From: Martyn White <Martyn.White@arun.gov.uk>
Sent: 20 September 2019 16:02
To: Planning.Responses <Planning.Responses@arun.gov.uk>
Cc: Zac Denton <Zac.Denton@arun.gov.uk>
Subject: R/180/19/PL & R/181/19/L

R/180/19/PL & R/181/19/L

The Current application relates to the removal of an existing window and widen this opening to create a new fire exit door to the building. The part of the building which is affected by the proposal is more modern in age, and as a result, contains much more recent built fabric.

DRAWING ELEVATION FIRE EXIT DOOR

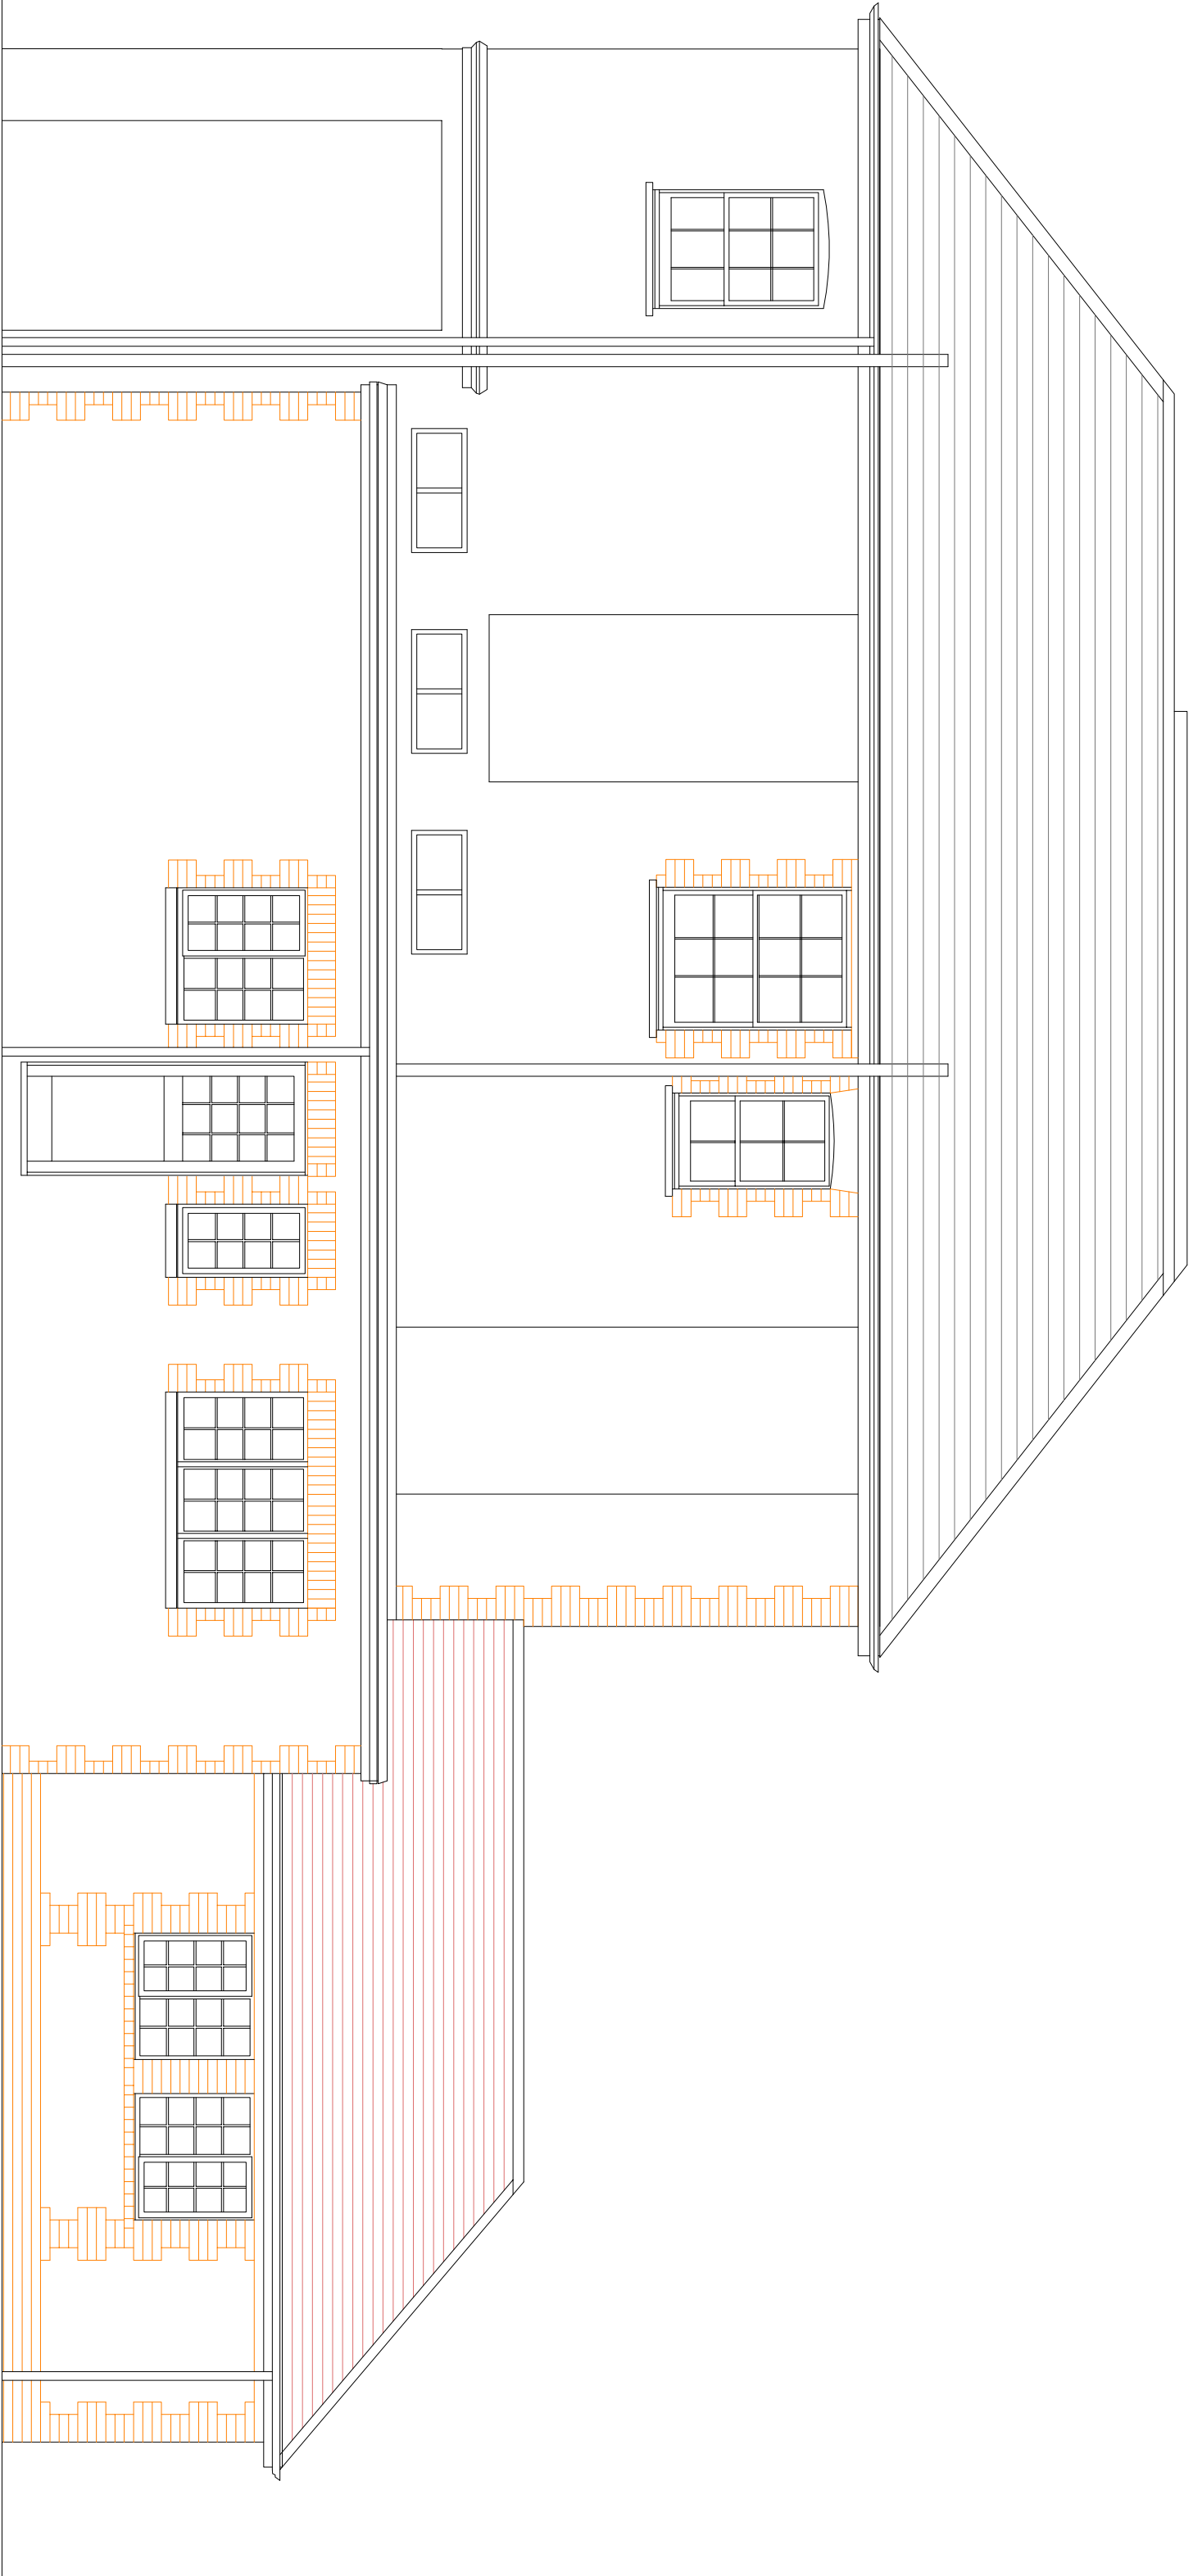
This proposal appears to have been carefully considered in order to ensure that the character and significance of the building is not harmed.

If minded to approve the application, please condition that details related to the door are provided to the Council for approval.
